Southampton to London Pipeline Project

Site Specific Plan - Turf Hill (tracked change)

Application Document: 8.58

Revision No. 2.0

Drawing number: B2325300-JAC-000-ENV-DRG-111156

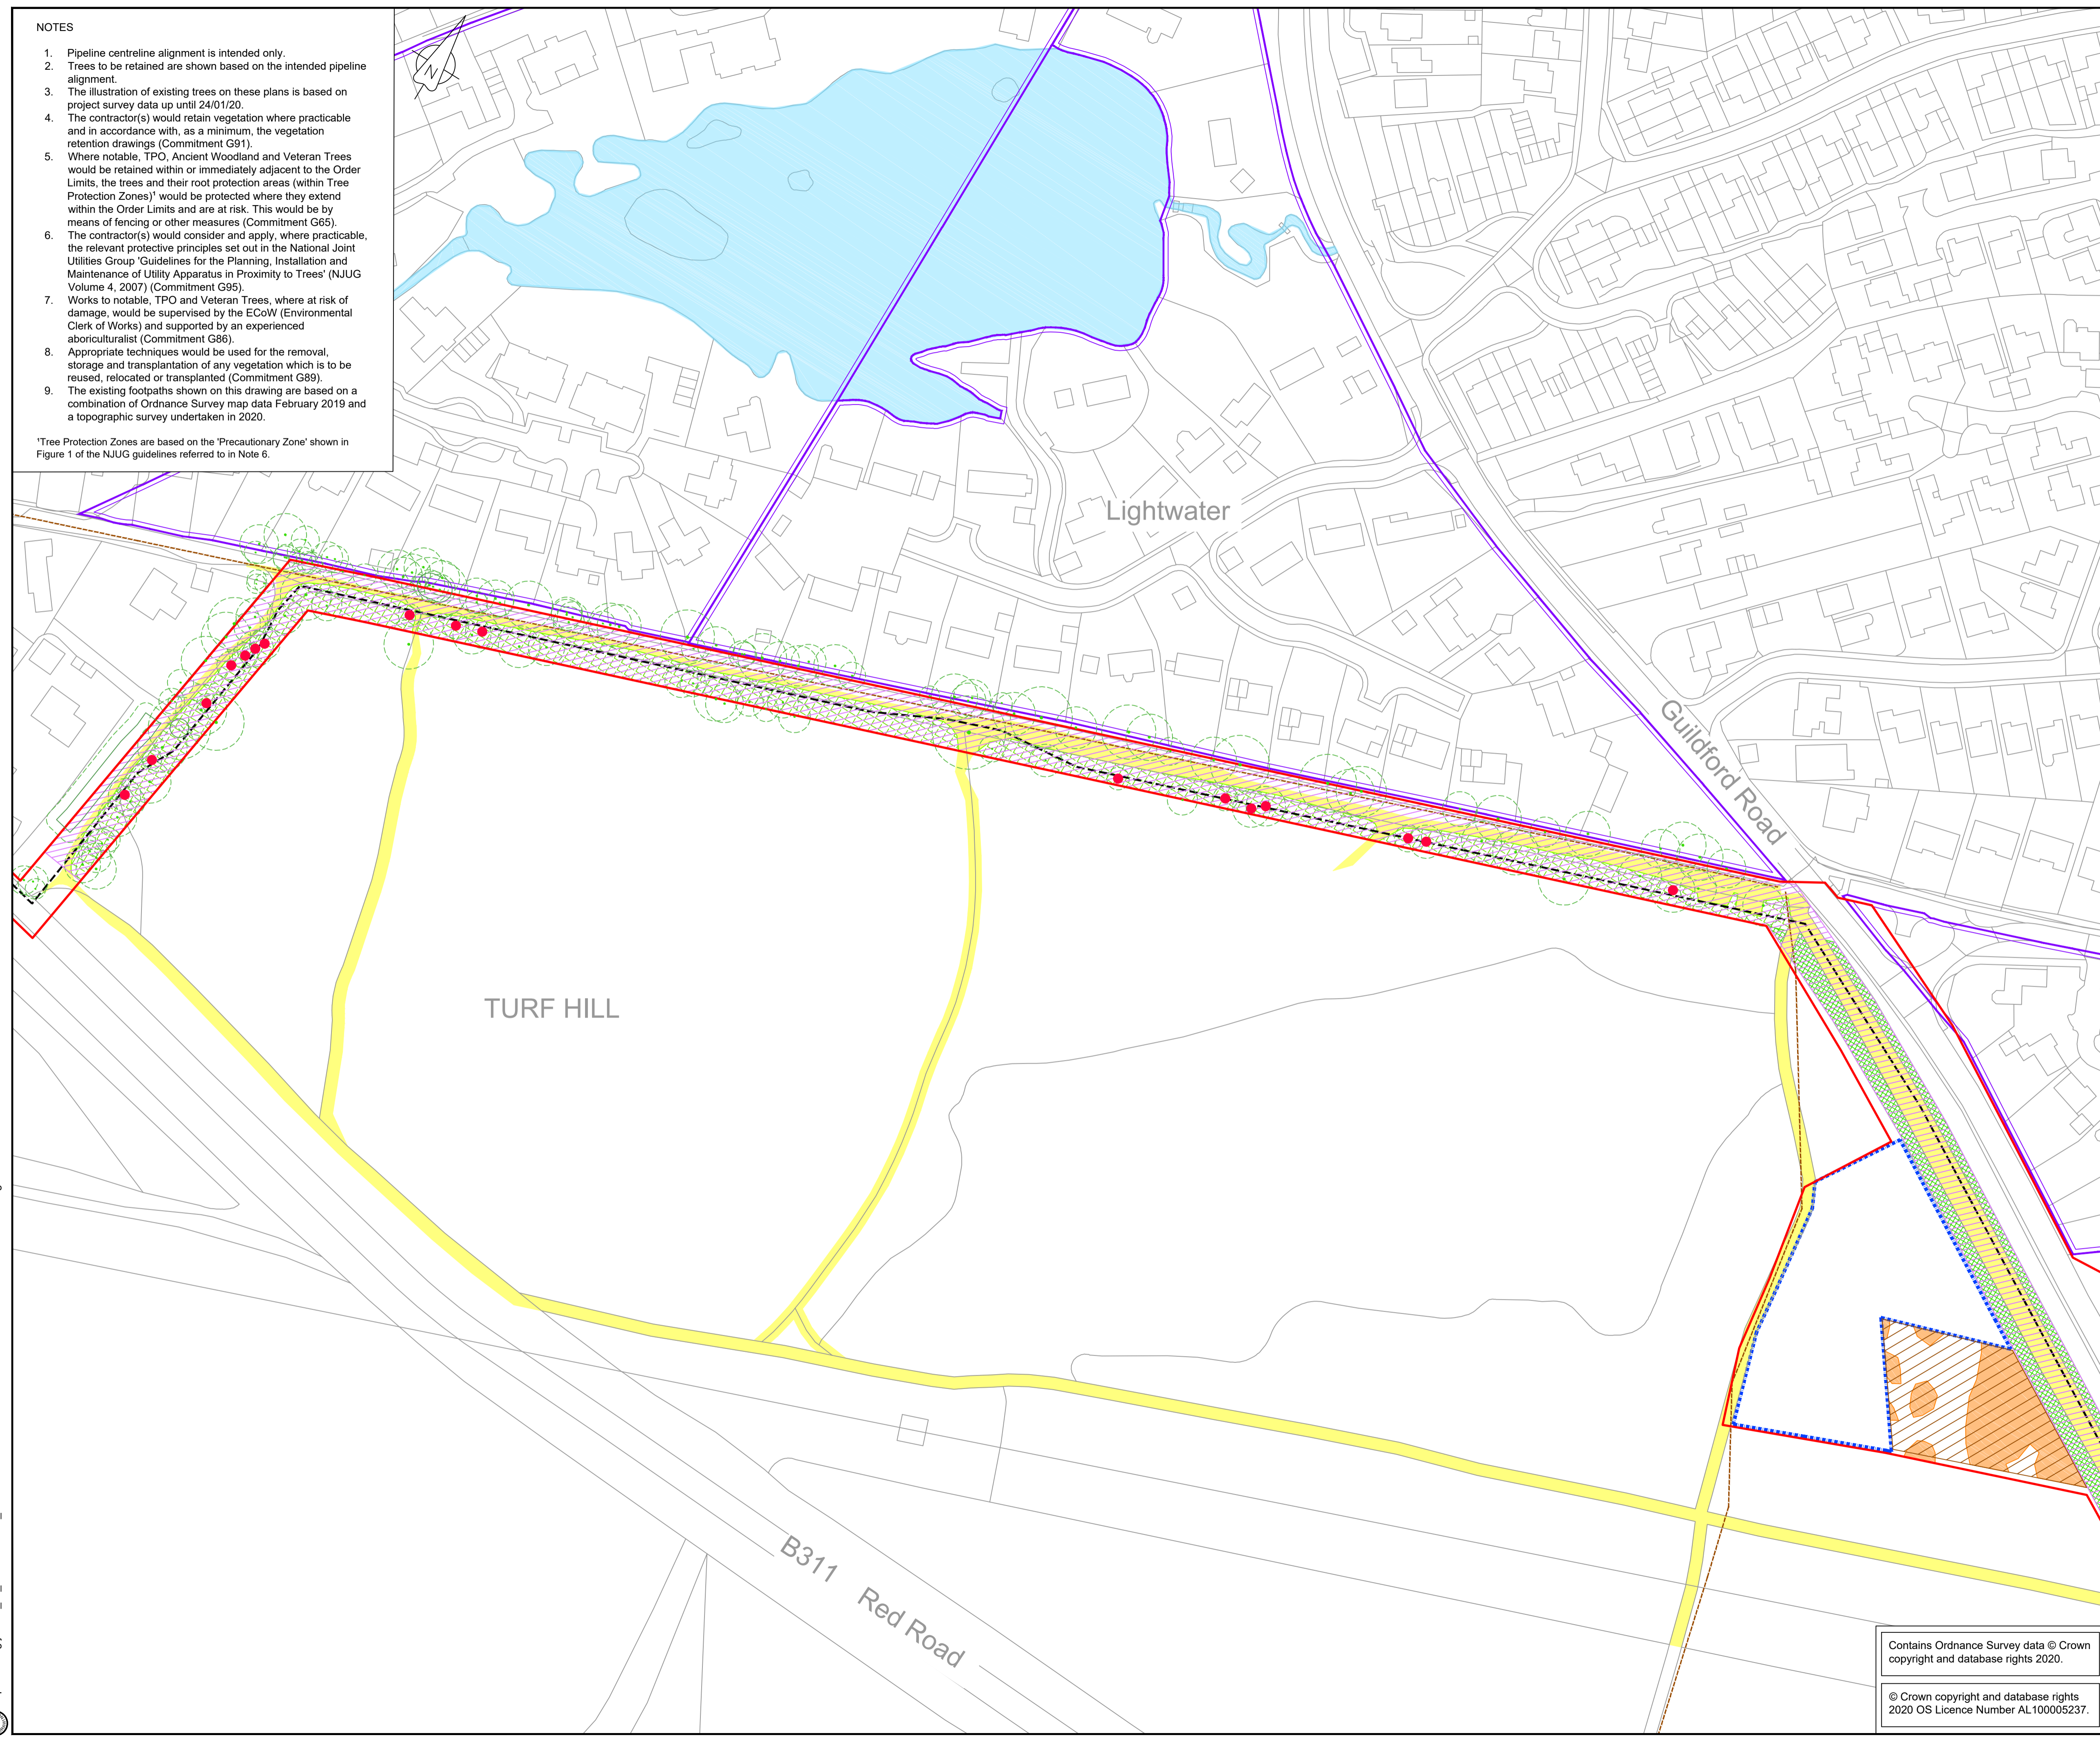
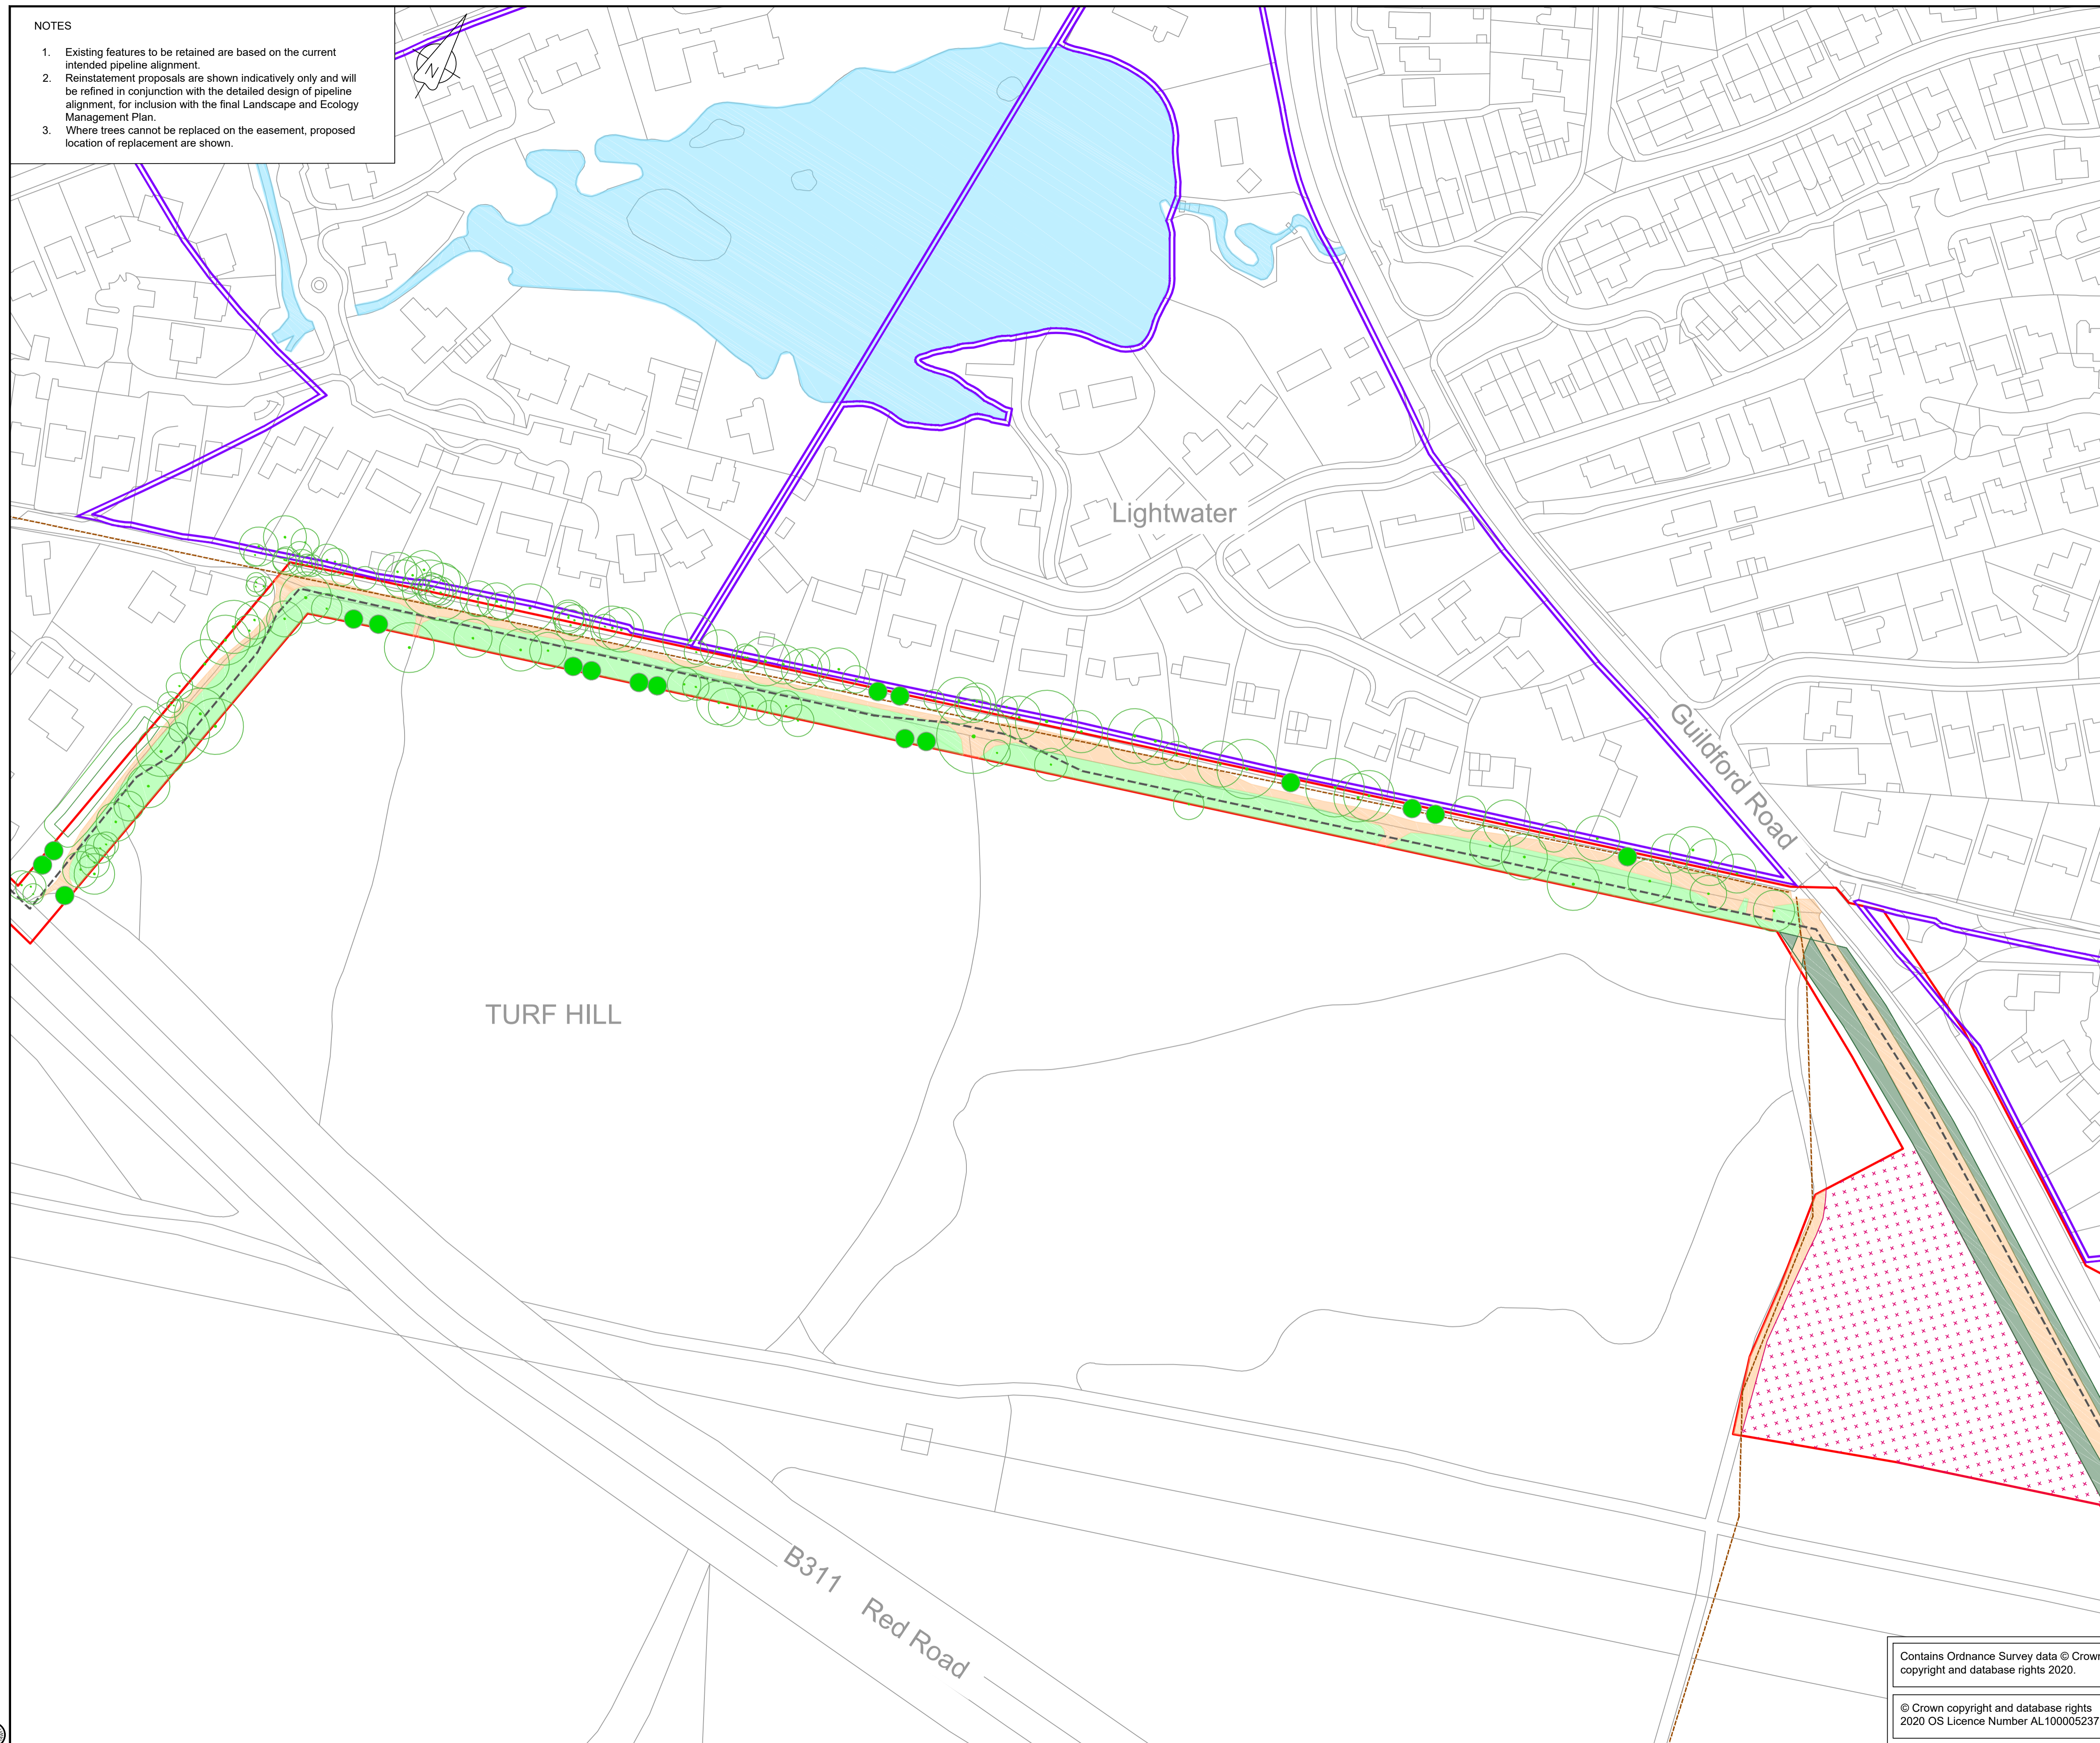
3.2.1 The local landscape character of the Order Limits that pass through Turf Hill comprises informal paths within coniferous woodland with some heathland and scrub understorey. There is also non-native invasive Gaultheria along the northern extent of the area. ~~It is anticipated that 17 of the surveyed trees will require removal.~~

3.2.2 Following the completion of the BS:5837 compliant tree survey based on individual trees over 75mm, it is anticipated that on the intended pipeline alignment the following trees will require removal:

- For the pipeline alignment along all three sides of the route at Turf Hill adjacent to The Folly, Heronscourt, Colville Gardens and Guildford Road – 21 trees to be removed. A mix of species and ages. To be reinstated
- Construction compound – 21 pine trees to be removed. No mature trees require removal. To be reinstated as heathland habitat.
- Pipeline alignment from the compound into Guildford Road. This crosses the younger largely self seeded belt of silver birch adjacent to the road – 18 trees to be removed. To be reinstated.

~~3.2.23.2.4~~ Vegetation screening and trees will not be removed from the boundary between the woodland path and the private properties along the northern boundary of Turf Hill.

~~3.2.3~~ A number of trees will be removed from the compound area.

~~3.2.4~~ The extent of tree removal adjacent to Guildford Road is still to be confirmed following more detailed design on the likely alignment.

3.2.5 Sections 3.4 and 3.5 below outline the approach that will be taken during construction to reduce the impact to vegetation and trees within the area, and this is reflected in the construction stage plan in Appendix B. As per Requirement 8(1)(a) of the DCO (~~Document Reference 3.1 (5)~~), the retention and removal of vegetation ~~within the park~~ must be undertaken in accordance with this Site Specific Plan (including the construction stage plan) unless otherwise agreed by the relevant planning authority.

3.4.2 The construction compound ~~5E~~ will be constructed to the west of Guildford Road via the access, on the edge of the heath where a small stand of Scots pine trees is present. ~~Trees and stumps~~

~~3.4.2~~ ~~The trees that form the screen to the edge of Guildford Road~~ will be ~~removed to allow a safe level area.~~

3.4.3 retained except where the temporary vehicle access needs to be formed. Within the working area, trees will be cut down to ground level or lopped by licenced professionals. As with typical woodland management, where safe to do so, tree stumps are left in situ to reduce the ground disruption and left to decompose, providing habitat for invertebrates.

- 3.6.3 Vegetation will be reinstated as shown in the reinstatement plan attached in Appendix B. This reinstatement plan will be included within Appendix B of the Landscape and Ecological Management Plan (LEMP) ~~(Document Reference 8.50)~~ for the approval of the relevant planning authority as per Requirement 8(1)(b) and Requirement 12 of the DCO ~~(Document Reference 3.1 (5))~~.
- 3.6.4 Where the topsoil has been stripped and stored, this will then be replaced after the works have been completed and either reseeded, specific to Turf Hill native species and with respect to seasonality, or left to natural regenerate.
- 3.6.5 Woodland will be reinstated with appropriate native species.
- 3.6.6 Where trees have been removed, they will be replaced at an adjacent location whilst outside of the 6.3m pipeline easement.
- 3.6.7 The vegetation will be subject to a five-year aftercare period.
